Examining Authority’s Issue Specific Hearing 2 (ISH2) Wednesday 28 to Friday 30 January 2026 Supplementary agenda additional questions

In response to the Examination Authority’s supplementary agenda additional questions issued on 16 January 2025, the Maritime and Coastguard Agency would like to comment as follows at Deadline 4, Tuesday 10 February 2026.

Number	Subject	Question to:	Question/Clarification	Response from MCA
Shipping and Navigation				
ISH2.029.	Concurrent restricted ability to manoeuvre (RAM) operations in the Sunk	Applicant and relevant stakeholders	Is SN12 of REAC [REP3-078] sufficiently effective as a commitment to avoid concurrent RAM operations with other projects in the Sunk area, or do concurrent RAM operations need to be precluded through the dDCO/ Deemed Marine Licence (DML). If so, provide suggested wording for the inclusion of such a provision in the dDCO/ DML.	<p>It is the MCA’s position that SN12 of REAC [REP3-078] is <u>not</u> sufficiently effective as a commitment to avoid concurrent RAM operations with other projects in the Sunk area.</p> <p>As the National Competent Authority for the SUNK Vessel Traffic Services (VTS), the MCA requests that our def

Scheme: SEA LINK  
 Document Title: STUDY AREA FOR SHIPPING AND NAVIGATION

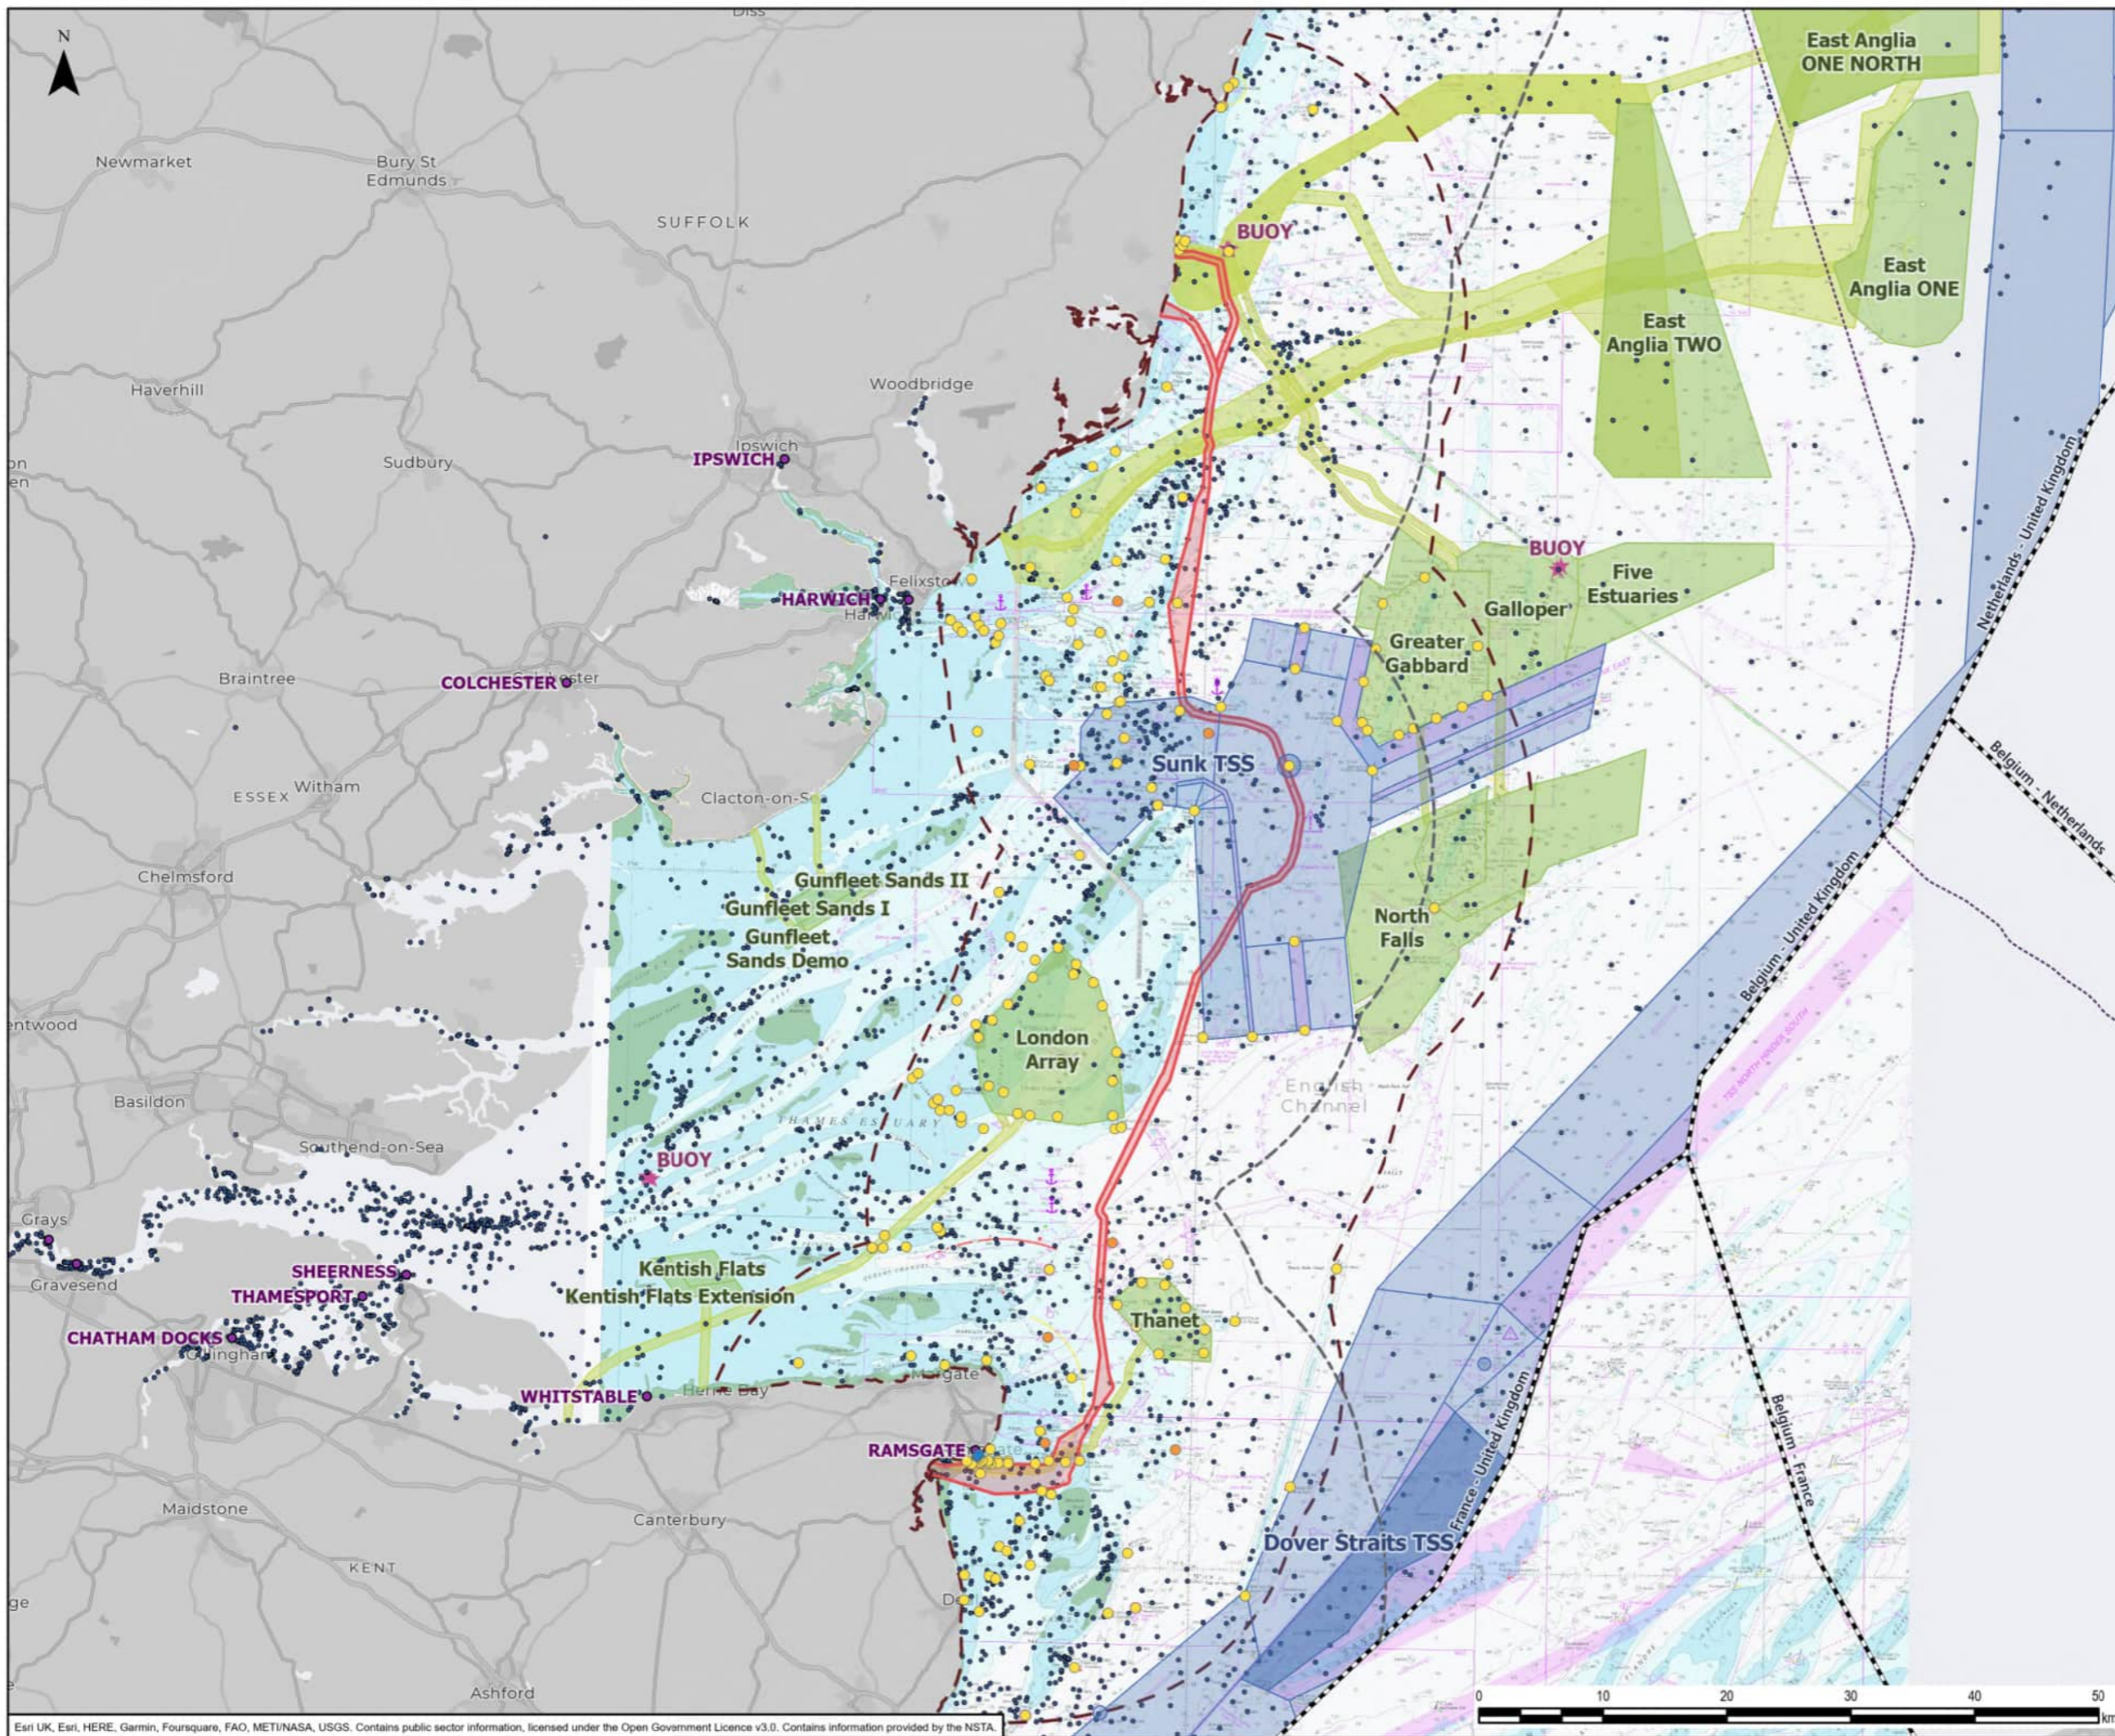
<p>1) No Sea Link project activities involving vessels Restricted in Ability to Manoeuvre (RAM) to operate concurrently with activities involving RAM vessels planned by the Five Estuaries and North Falls offshore windfarm project in the SUNK area (or other future projects), within the MCA defined area bound by the following coordinates:</p>

<p>And</p> <p>2) No Sea Link project vessels with Restricted Ability to Manoeuvre (RAM) (cable laying, UXO clearance, survey) are to operate when visibility is below 2 nautical miles within the MCA's defined area in figure 1.</p> <p>S12 of the REAC does not currently secure both aspects sufficiently.</p> <p>The MCA's justification for our defined area of interest is as follows:</p> <p>1) The defined area of interest in figure 1 is a relatively small area of navigable sea room considering the size and draft of the vessels involved. Pilot boarding/dis-embarking is an 'area' and not a specific point. Vessels are usually requested to come to a position 1NM</p>	ID	Latitude	Longitude	A	51° 53.0032' N	001° 38.2325' E	B	51° 53.0032' N	001° 47.2371' E	C	51° 48.0528' N	001° 47.2371' E	D	51° 48.0528' N	001° 38.2325' E
ID	Latitude	Longitude																	
A	51° 53.0032' N	001° 38.2325' E																	
B	51° 53.0032' N	001° 47.2371' E																	
C	51° 48.0528' N	001° 47.2371' E																	
D	51° 48.0528' N	001° 38.2325' E

<p>to the east of the pilot boarding area or 1.5 northeast for the ultra-large vessels. The vessels are then given a heading to board which could be any heading based on the weather / sea conditions. As such, vessels are boarded anywhere to the east of a line drawn North-South through the pilot diamond, including in the anchorages. The same applies to vessels disembarking a pilot which could be anywhere in (or close) to one of the Deep-Water Routes in the Sunk Inner.</p> <p>2) Additionally, the MCA is requesting a larger defined area of interest figure 1 than was previously permitted for the North Falls and Five Estuaries projects. When those projects were approved, both were located to the south of the area, which still left a small section of navigable sea room to the north for other activities. However, the Sea Link project now occupies the northern part of the area significantly reducing the remaining safe sea room and further limiting the ability to conduct marine operations or transits to and from PLA and HHA.</p> <p>3) This is further compounded as almost all vessels exit the Sunk Inner to the Southeast to follow the IMO routing measure in the Strait of Dover which is considered as one of the busiest and most complex shipping lanes in the world. If all three project operations were taking place at the same time, the southeast corridor would be reduced to less than 1NM wide.</p>

<p>4) Also, a recent trend is that, due to the northward migration of the Long Sand bank (within the SUNK area), the larger vessels using the Long Sand Head two-way route increasingly tend to divert into the Sunk Inner (north of the magenta line marking the northern limit of the LSH route), to maintain safe navigable depth. This behaviour further reduces available sea room particularly when vessels are simultaneously outbound from the PLA or HHA and can therefore create additional navigational constraints. This can be seen in Figure 2 attached below, sourced from applicants' submission APP- 284- Fig. 6.4.4.7.4.14.</p> <p>5) A further complication is that, during the summer months, numerous sailing vessels often cut directly across the area on a straight southeast course from Harwich. This reduces available sea room and is made more challenging by the fact that many of these pleasure craft have low-power radios and only carry Category B AIS transponders, making it difficult or sometimes impossible for VTS to detect or communicate with them.</p> <p>Similar issues arise with fishing vessels, which often switch off their AIS to avoid revealing their location to other fishermen. These factors further constrain the already limited safe sea room, both before and after a vessel has a pilot on board. This risk should not be underestimated, as the operators of</p>

<p>such vessels are frequently unaware of, or do not fully adhere to, the Collision Regulations, including the requirement not to impede deep draft vessels in designated deepwater routes.</p> <p>In summary, the MCA is seeking this defined area of interest in figure 1 to account for a credible worst-case scenario, namely, multiple RAM operations taking place within an already constrained sea room, potentially in restricted visibility, and in proximity to some of the largest vessels operating worldwide. An incident involving an ultra-large vessel, such as one comparable to the <i>Ever Given</i>, would have significant safety implications, attract global media attention, and could adversely affect the UK economy. The proposed restriction is therefore both proportionate and essential to ensuring the Safety of Navigation.</p>
--	--	--	--	---
